Client	Hawthorn
Project	Portland, ME
Lead Designer	
Production Manager	Jason DiOrazio
Production Staff

Revision #	Sheet	Description of Change	A0.0 Dotted?	Assigned Date	Responsible Staff	Completion Date
6	A0.0	Added revision 6 to title block	Y			
	A0.1	Elevator Equipment room moved to rear of building. Wall type revised in Hall 148.				
		Rear doors revised to storefronts.				
		Standpipe cabinet added in core. Standpipe note added to Legend.				
	A0.2	Tv room windows removed and revised.				
		Standpipe cabinet added in core. Standpipe note added to Legend.				
	A0.3	Unit 323 revised.				
		Standpipe cabinet added in core. Standpipe note added to Legend.				
	A0.4	Standpipe cabinet added in core. Standpipe note added to Legend.				
	A1.1	Carports added. Parking spaces revised.				
	A1.7	Dtl 1 removed.				
	A1.8	Dtl 5 added.				
	A1.9	Dtl 7 added. Zip system note added and zip added to details.				
	A2.1	Elevator Equipment room moved to rear of building. Wall type revised in Hall 148.				
		Rear doors revised to storefronts.

SCALE: 1/4"=1'-0"

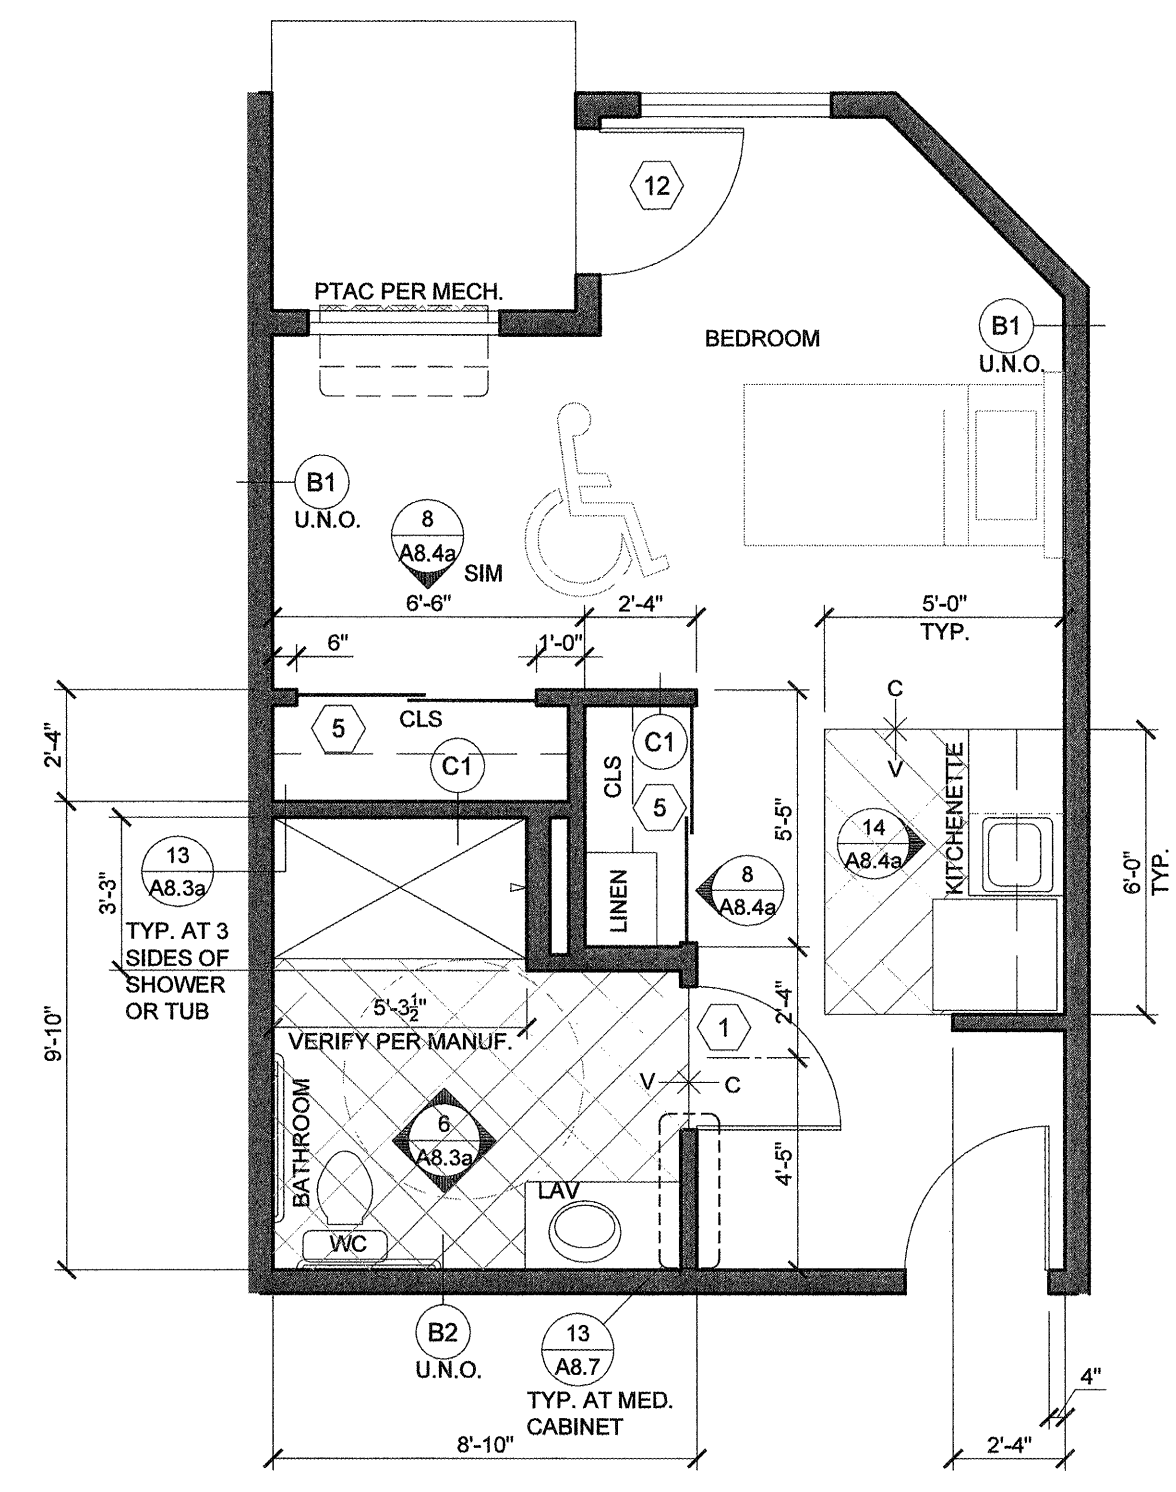
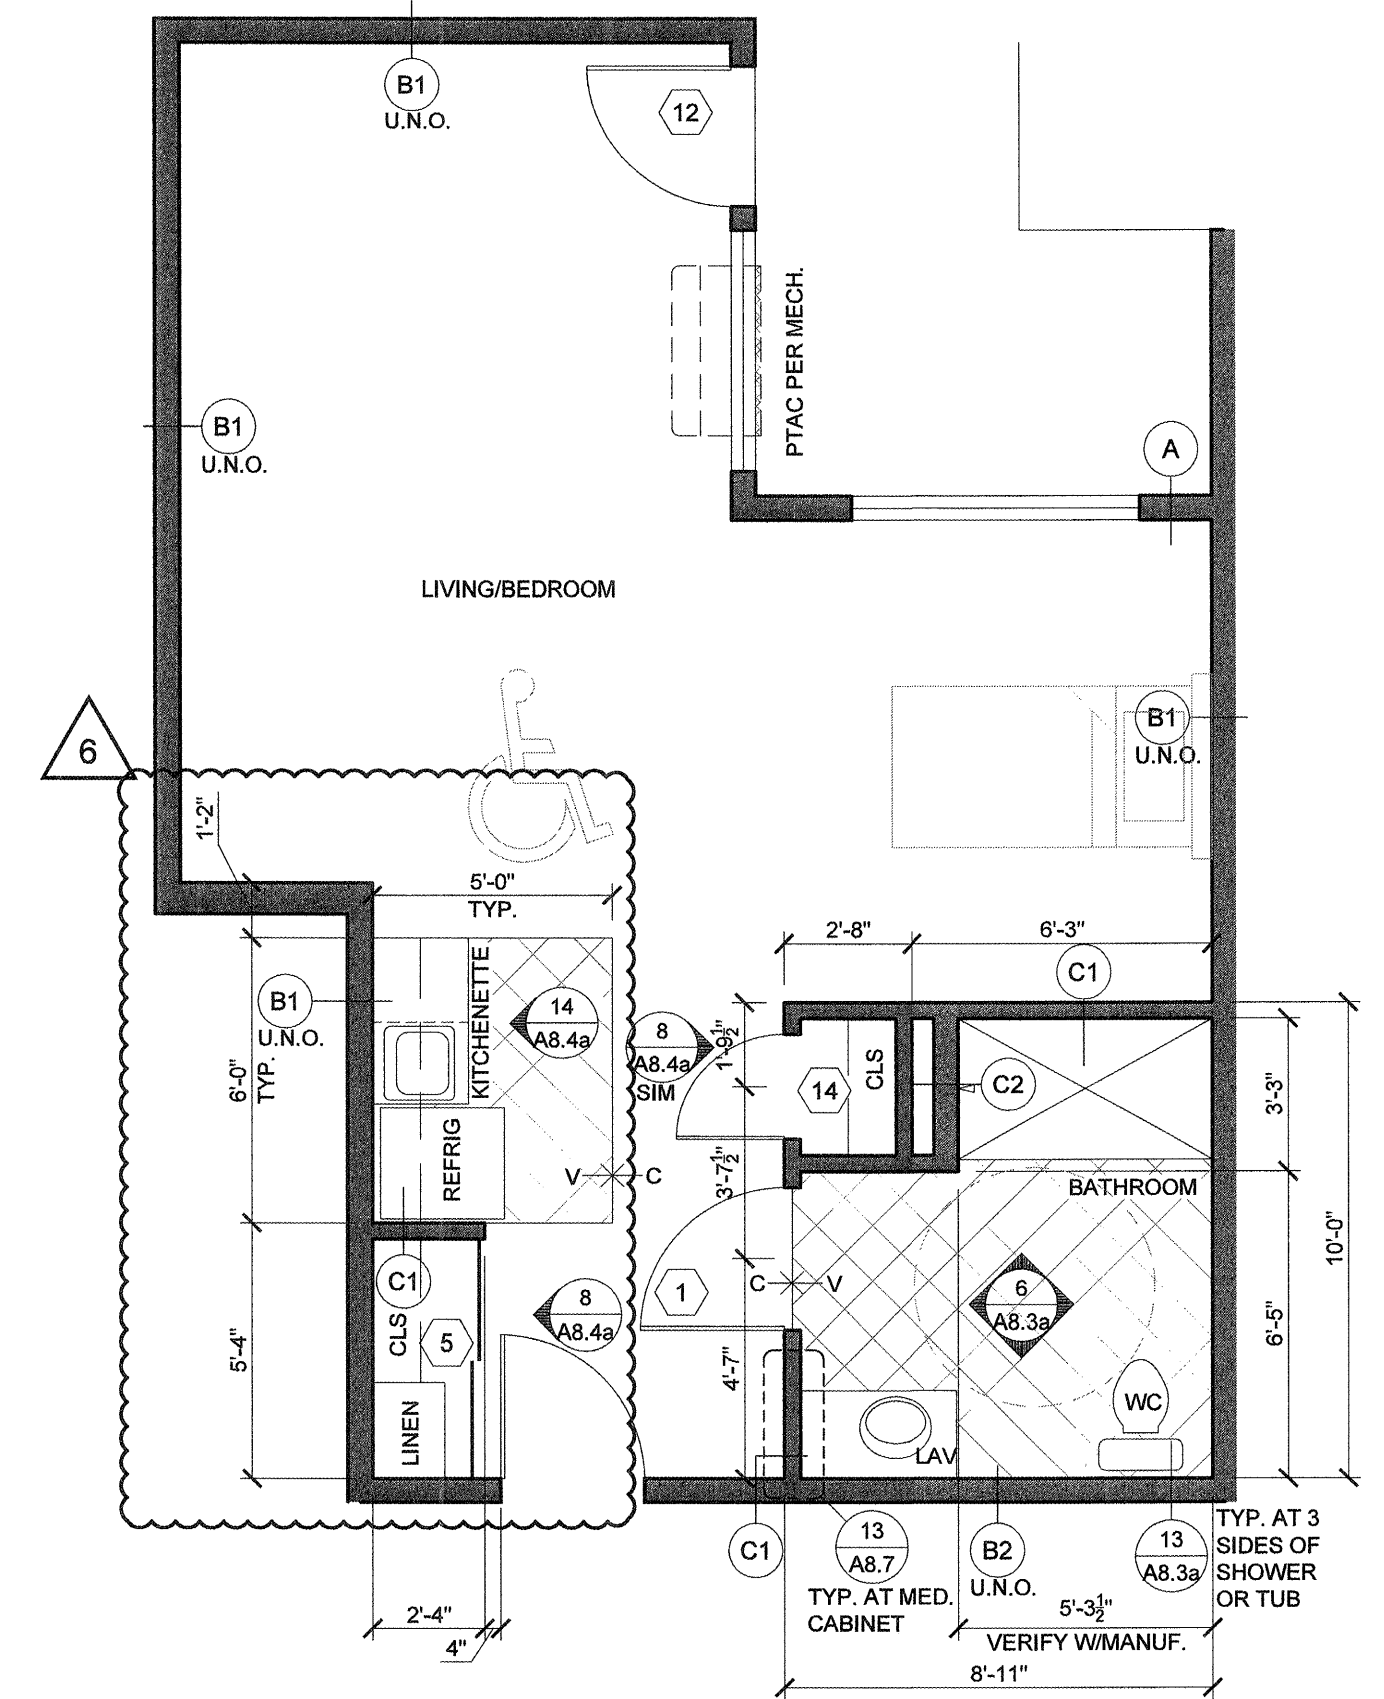
A4.6	Callout added. Vault added at B4.				
A4.7	Dtl 7 Reading room revised. Dtl 2 updated per new ceiling at Activity room				
A4.8	Dtl 8 and 12 soffit heights revised.				
A4.9	Dtl 3 soffit revised. Dtl 10 revised.				
A5.1	Dtl 8 note removed.				
A5.3	Dtl 2 revised to remove Elevator Equipment room.				
A5.4	Dtls 4 and 6 revised.				
A5.5	Dtl 6 2x8 walls added and dimmensions revised.				
A5.7	Dtl 6 revised.				
A5.9	Dtl 6 revised.				
A5.10	Dtls 2 and 4 2x8 walls added.				
A6.0a	Insulation values added and callouts revised. Reading room fireplace revised. Deck floor slope revised.				
A6.0b	Insulation values added and callouts revised. Rafter revised outside of Dining. Ceiling information updated at Activity room				
A6.0c	Insulation values added and callouts revised. Rafter revised outside of Dining in Section C and E.				
A6.1a	Insulation values added and callouts revised. Catwalk revised. Staff room updated.

DATE 8/28/2015
REVISED DATE 9/22/2015
2/2/2016
SHEET E1.7P

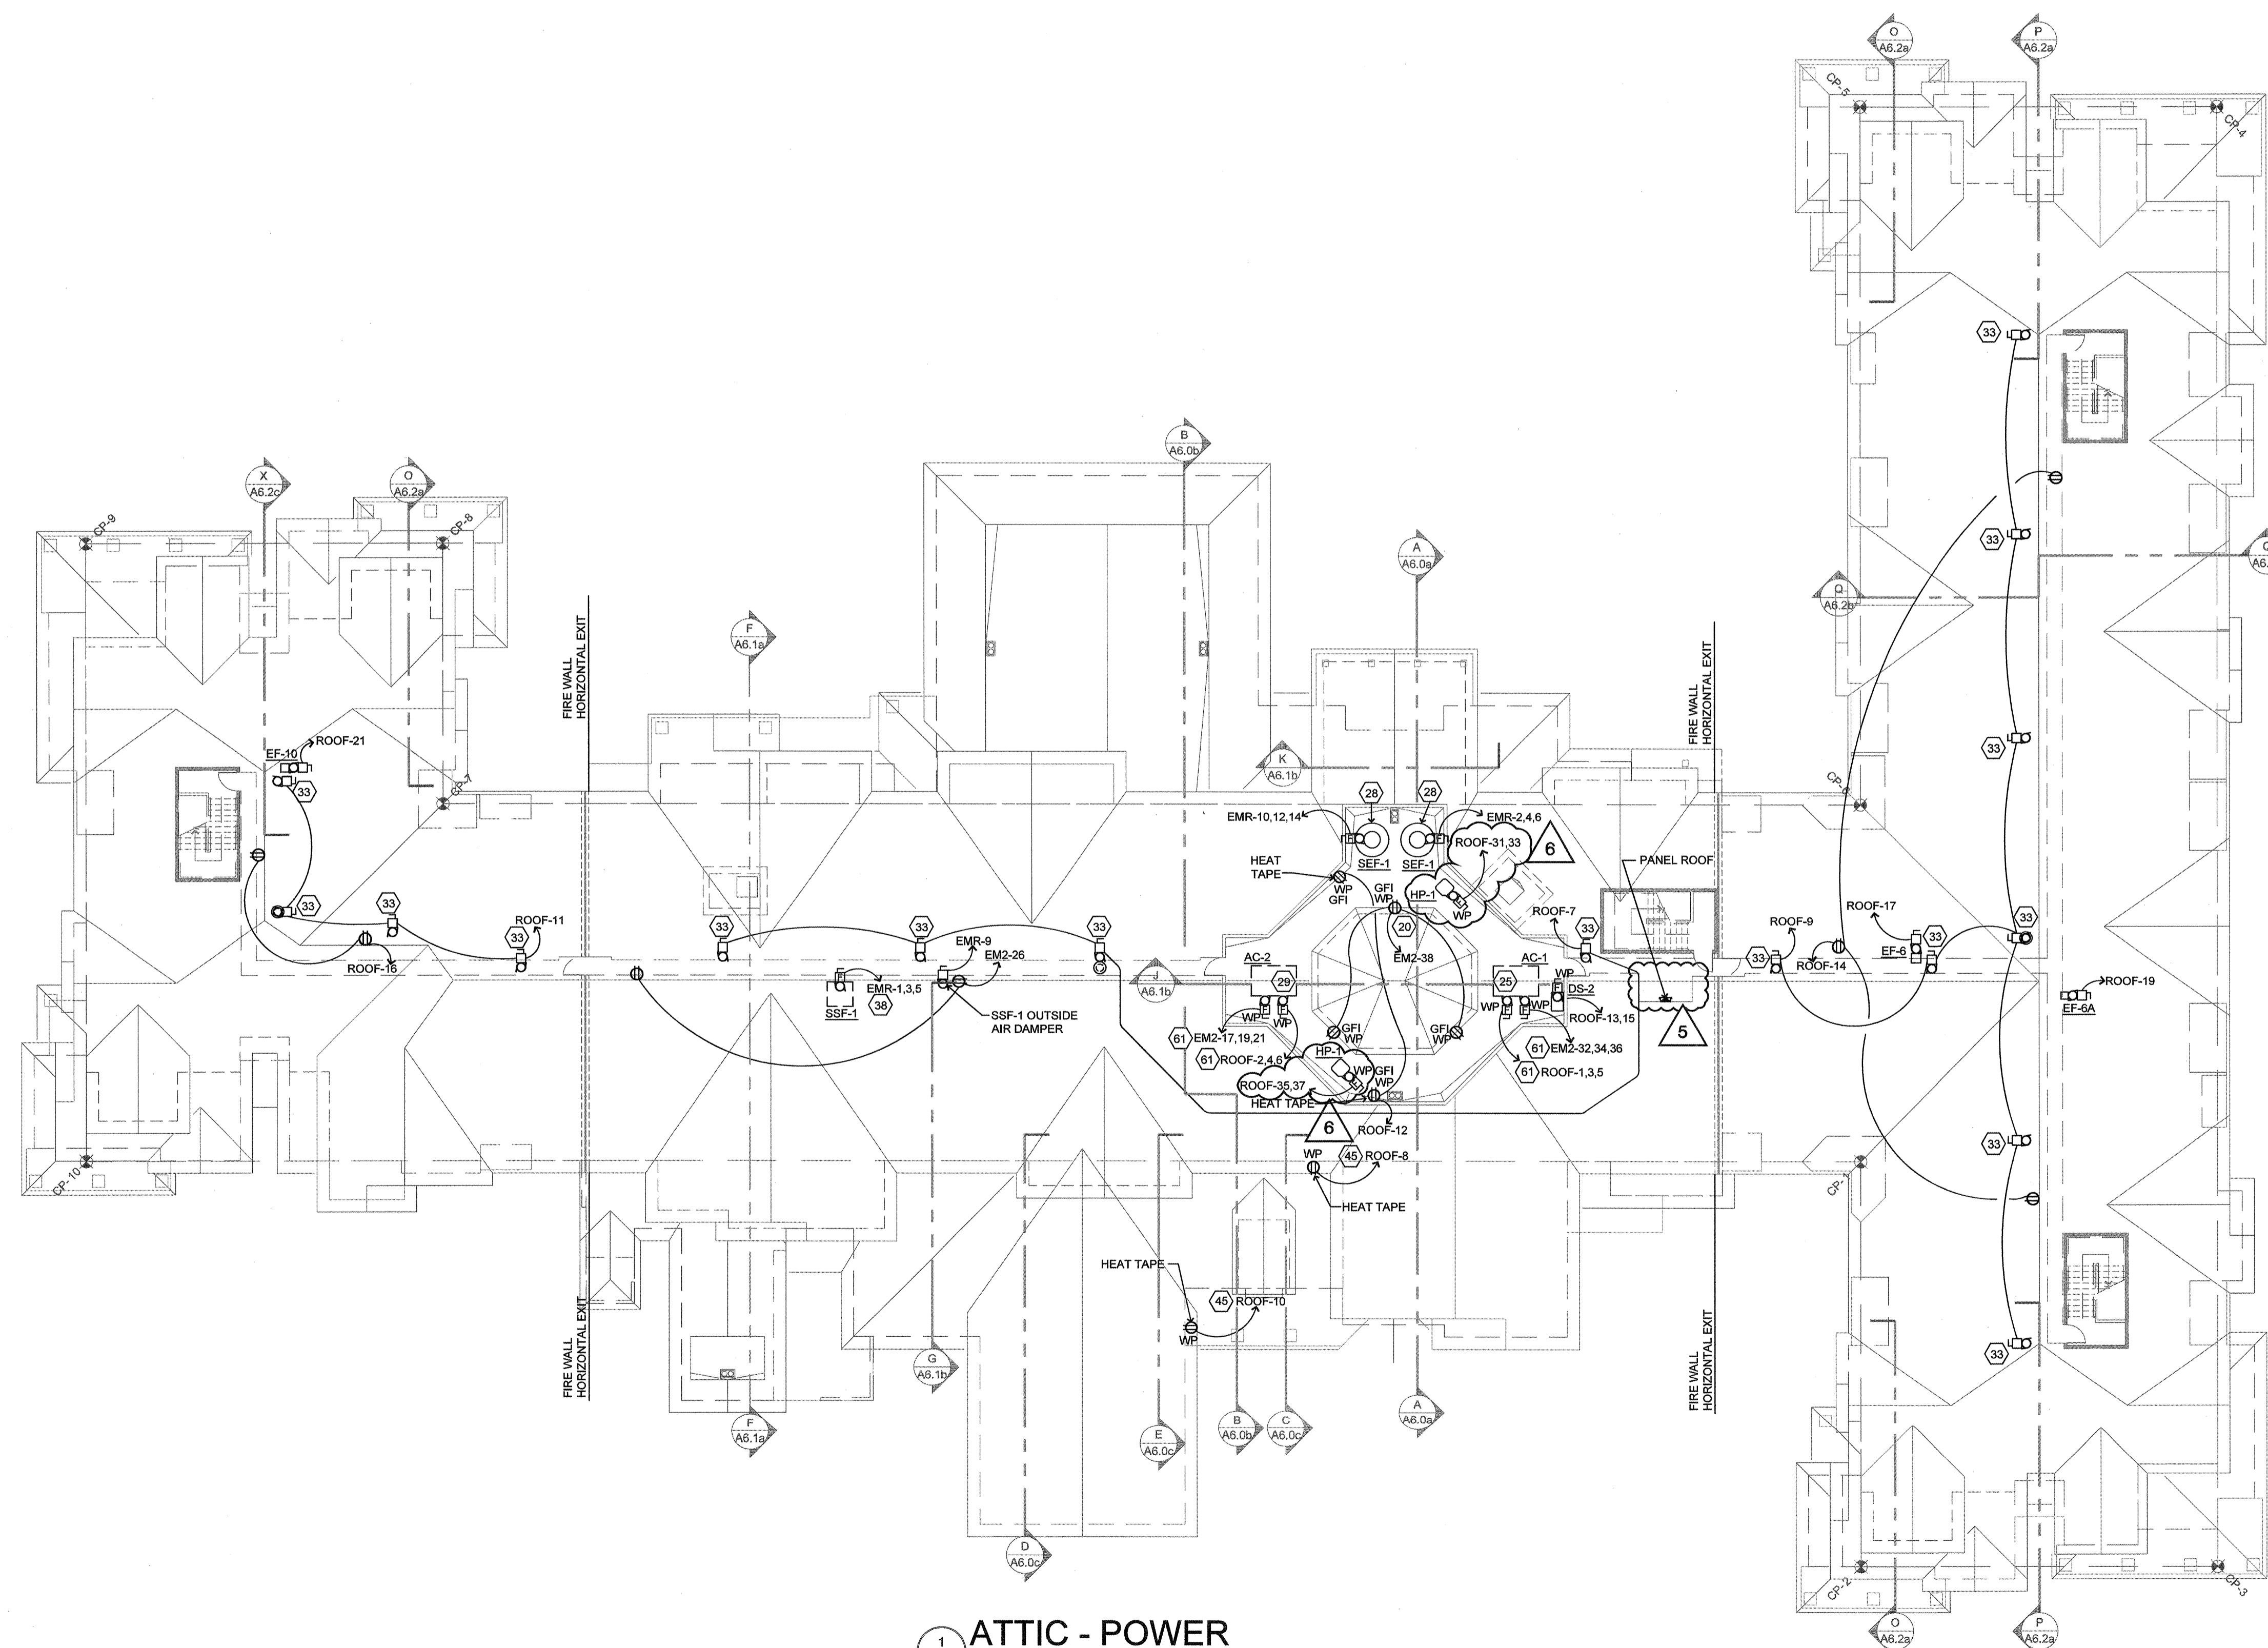
M3.4		Unit 401 CRD added. HVAC key note 31 added. PTAC note added.			
M3.5		Mech equipment above activity moved. Mech equipment added to roof.			
		HVAC key note 31 added. PTAC note added.			
M3.6		Louver added to Mech. Room. Laundry air transfer revised. Return duct added to all floors.			
		HVAC key note 31 added. PTAC note added.			
M3.7		Laundry air transfer revised. Return duct added to all floors.			
		HVAC key note 31 added. PTAC note added.			
M3.8		One exhaust duct removed.			
		HVAC key note 31 added. PTAC note added.			
M4.0		Dtl 5 added.			
M4.1		Dtl 12 removed.			
M4.2		HP-1 revised. EF-1a and EF-8a added. Dtls 1 and 2 revised.			
M4.6		Equipment revised.			
M5.1		Run Sprinkler pipe in soffit.			
M5.2		Section updated.			
E1.1L		Dimmers added. Rear Foyer door moved. Office 151 lighting revised.			
E1.2L		Dimmers added to Reading room.			
E1.7P		HP added to Mech. Well.			
E2.3b		Panel schedule revised. Gym HP-1 added.
